MEMORANDUM

TO: All Staff
FROM: Justin Turnbull, County Surveyor 
DATE: October 3, 2017
SUBJECT: County Survey Review of Boundary Line Adjustment 17-00016 (Miller)

# MILLERWEBER EXISTING PARCELS

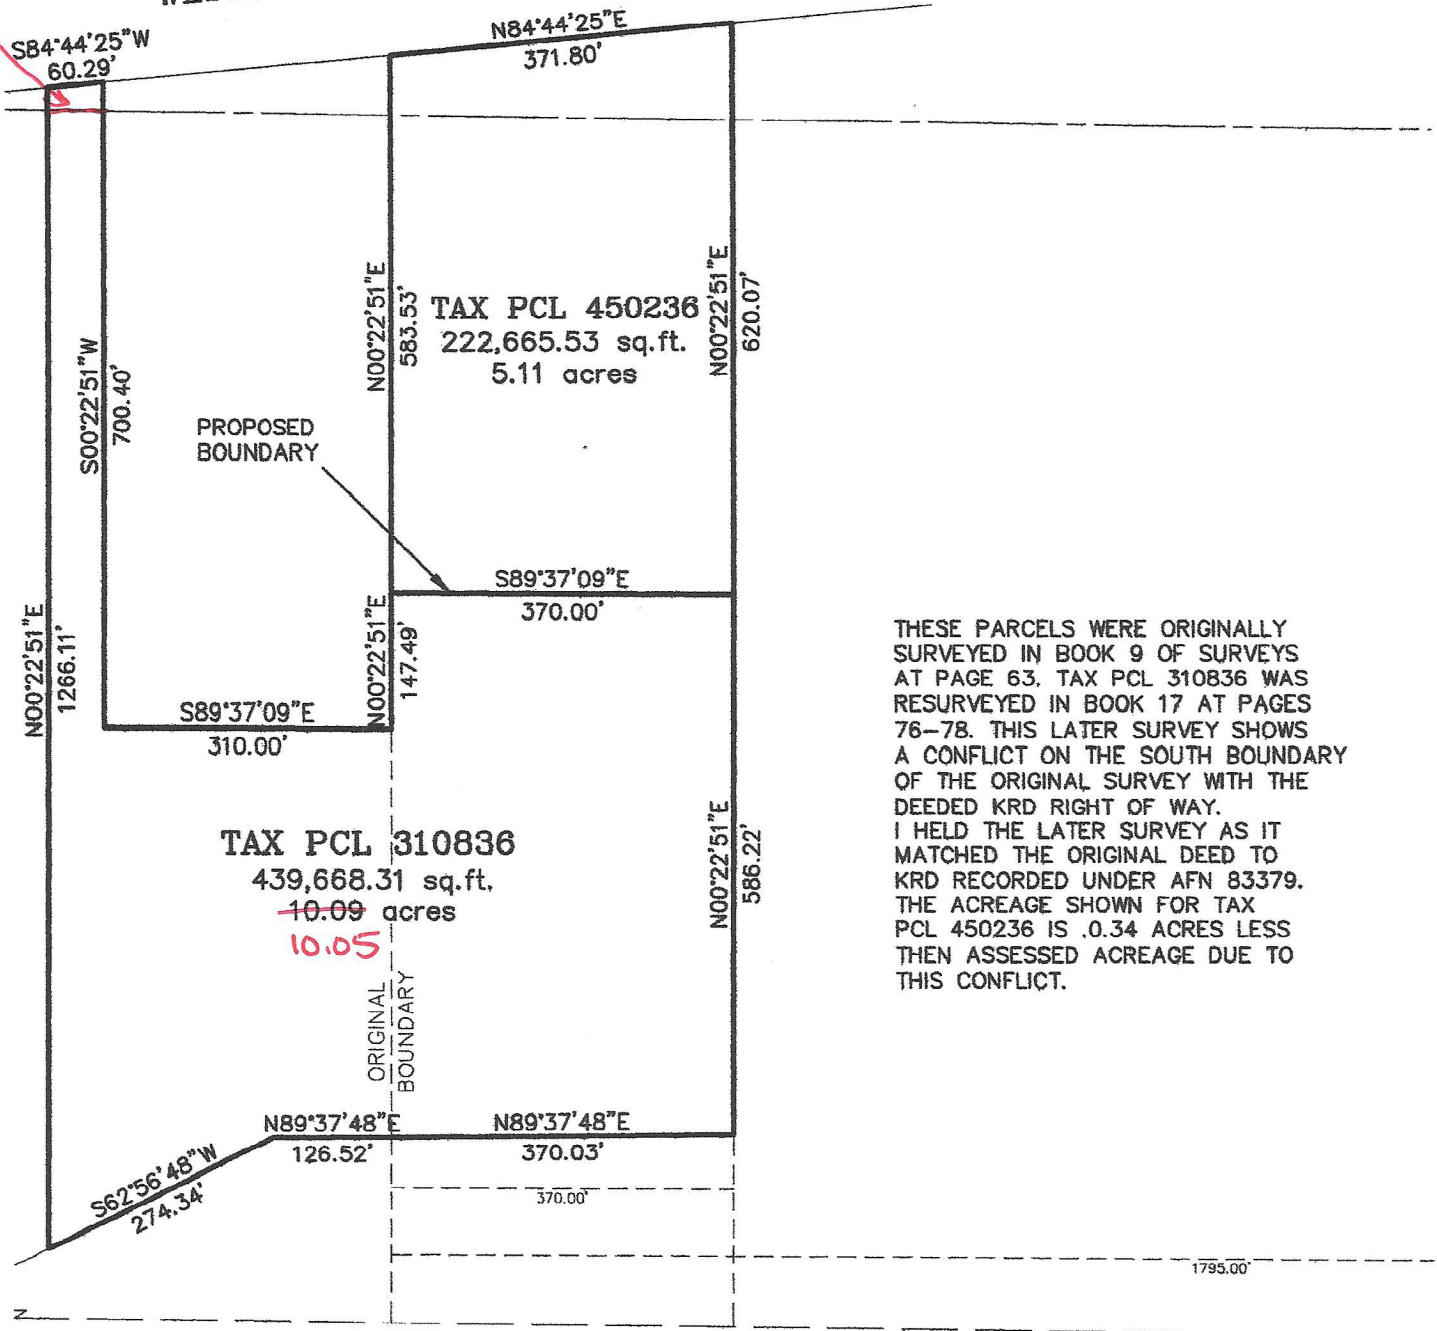
1. Westside Road should include ownership, width, and surfacing. (EX Westside Rd. 60' County R/W – Paved).
2. Minor typo in paragraph 2 of legal descriptions.
